**Óglaigh
na hÉireann**
DEFENCE FORCES IRELAND

25th May 2021

Proposed Wind Farm at Ticknevin, Carbury Co. Kildare and Edenderry Co. Offaly.
ABP Case Number: 310107

DRAWING NUMBER: 21992-MWP-00-00-DR-C-5003

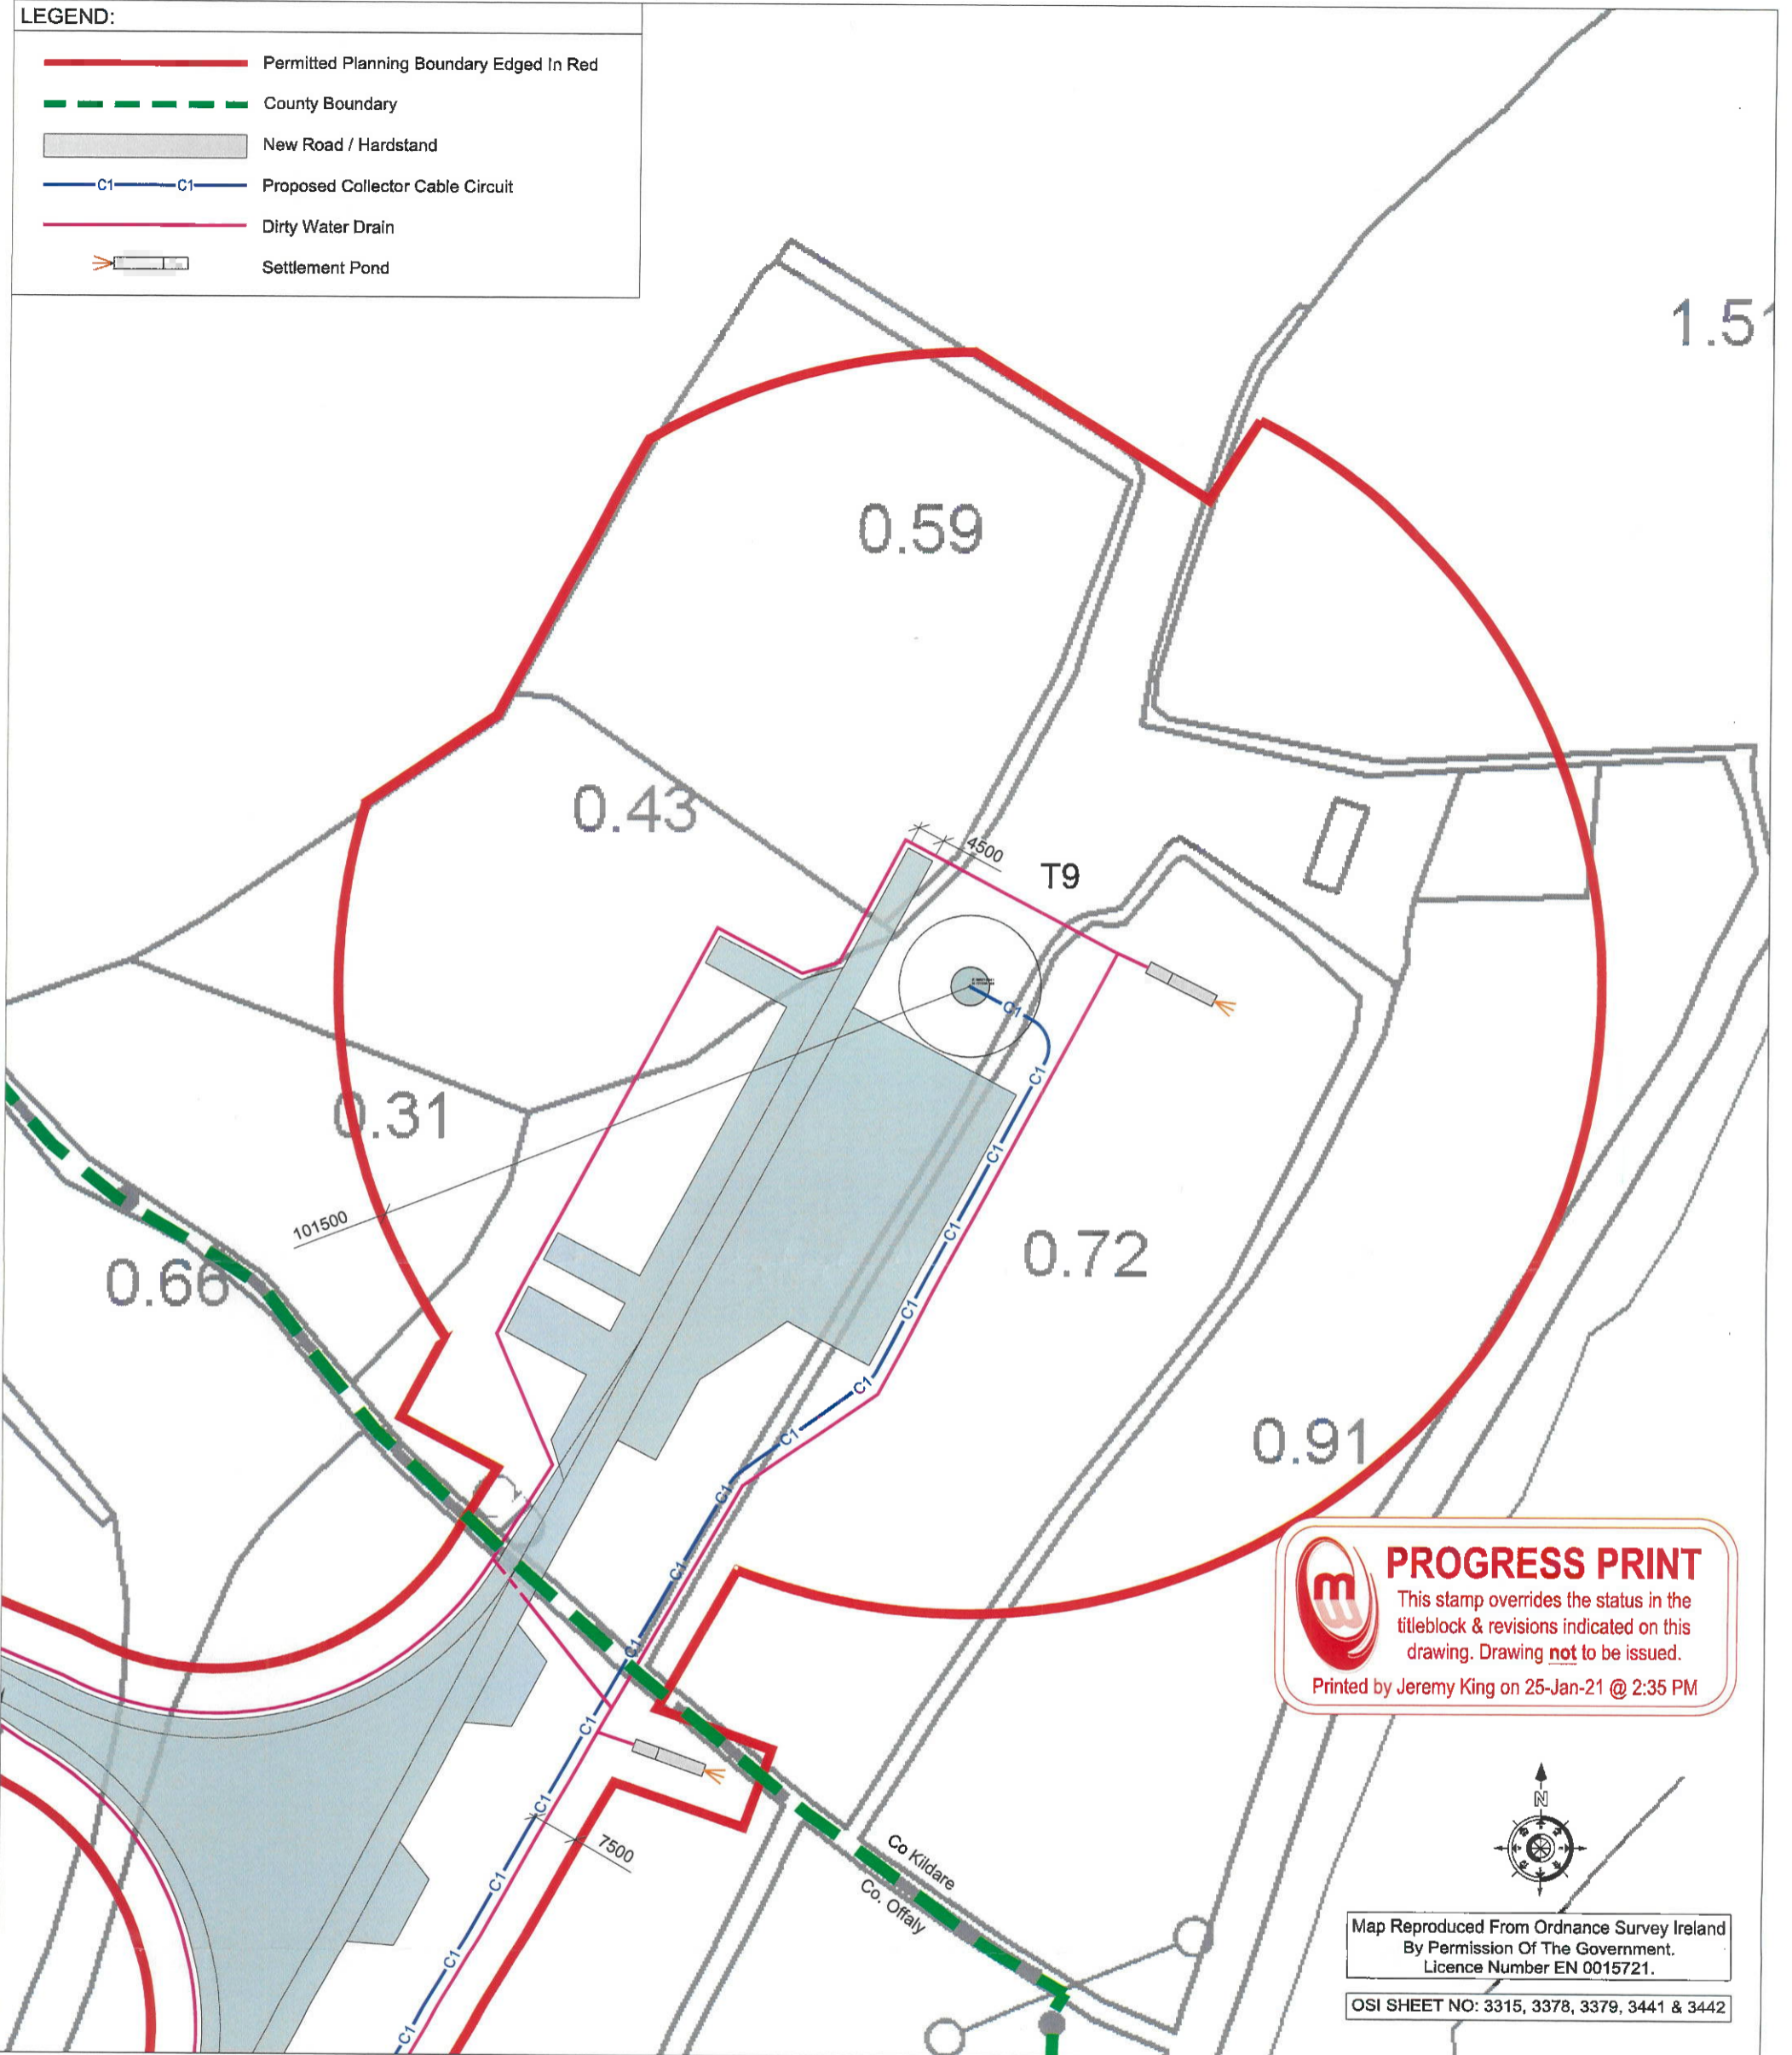
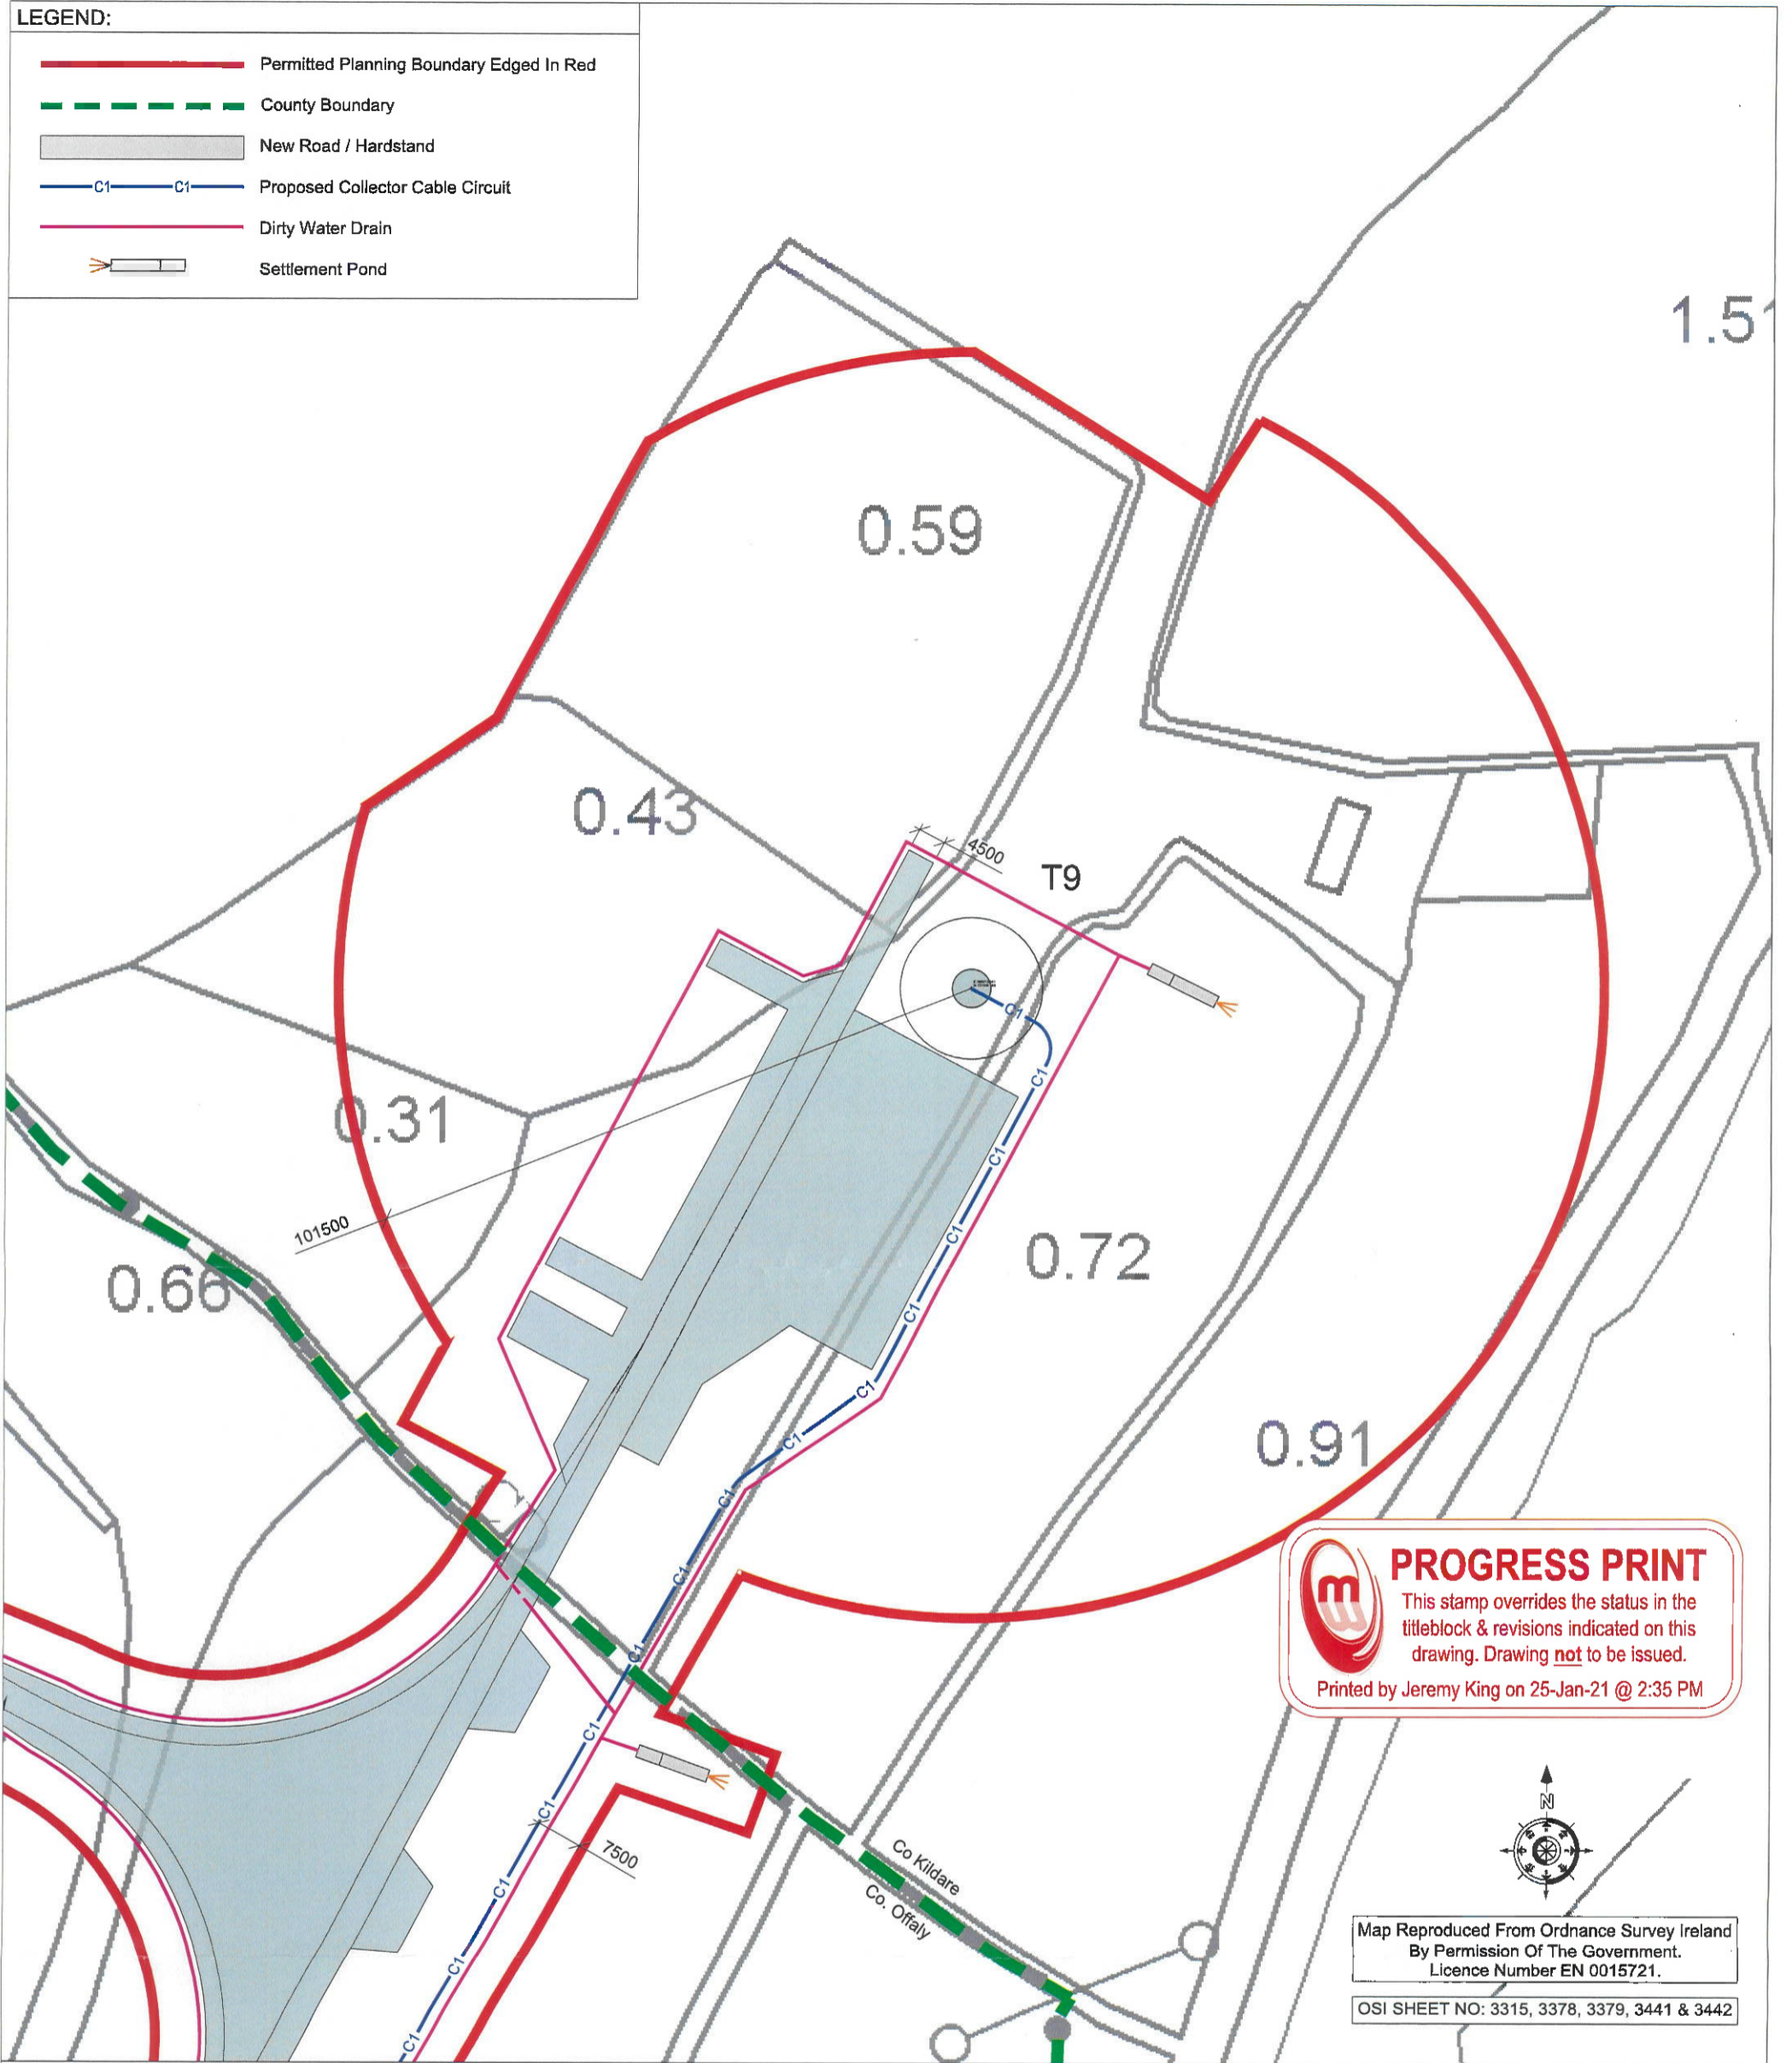
- b. A portion of the proposed development lies on lands underlying military airspace EI-R16 and MOA 4 within the 20 nautical miles (NM) area of Casement Aerodrome that is protected against tall structures. At its nearest, the wind farm boundary is 19.8NM from Casement Aerodrome Reference Point (ARP).

- c. The routes taken by Air Corps aircraft to multiple training areas in the MOA 4 and MOA 5 pass through the area of the proposed development. The proposed development will reduce aircraft navigability in the EI-R16 and MOA 4.

**WTG SIDE ELEVATION**  
SCALE 1:1,000

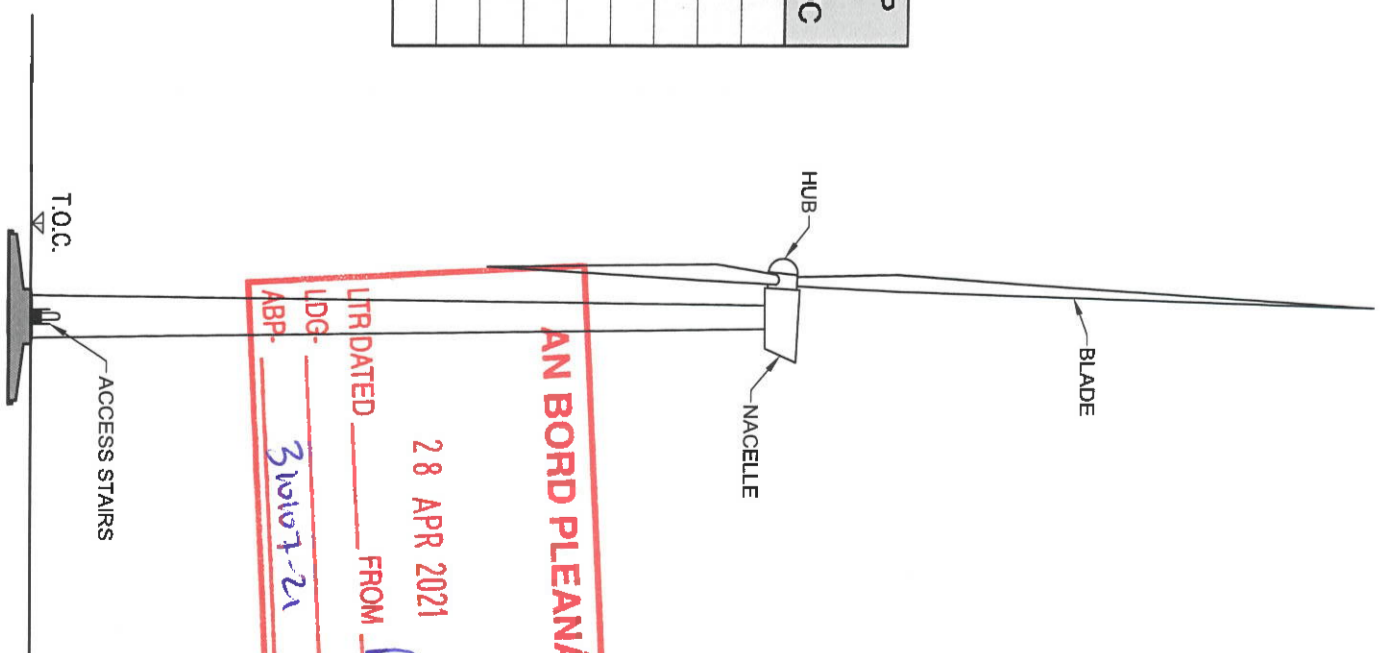
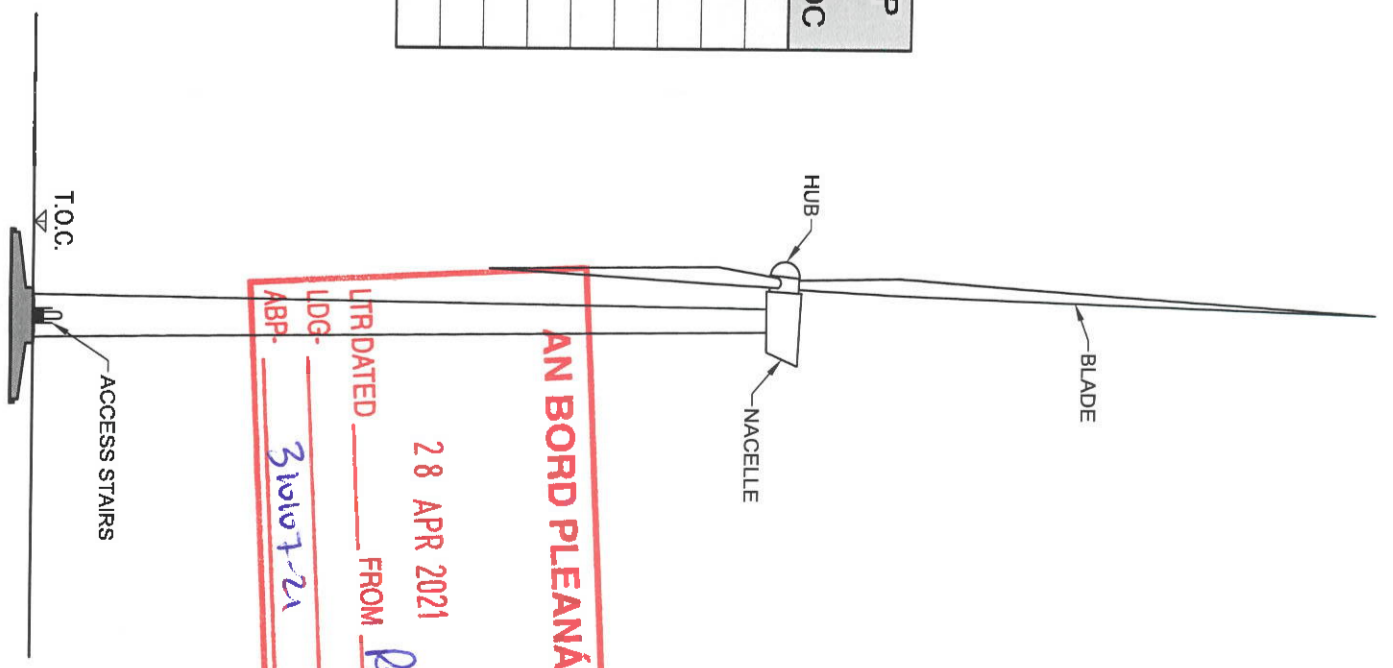
- d. A tall structure does not have to penetrate restricted airspace to impact Air Corps flight operations. The ability of transiting aircraft to fly underneath the lower level of restricted airspace so remaining clear of restricted airspace is a standard method employed by Military Air Traffic Services to provide separation from Instrument Flight Rules (IFR) traffic operating above.
The proposed development while not penetrating the EI-R16 will effect transiting aircraft to remain clear and below restricted airspace.
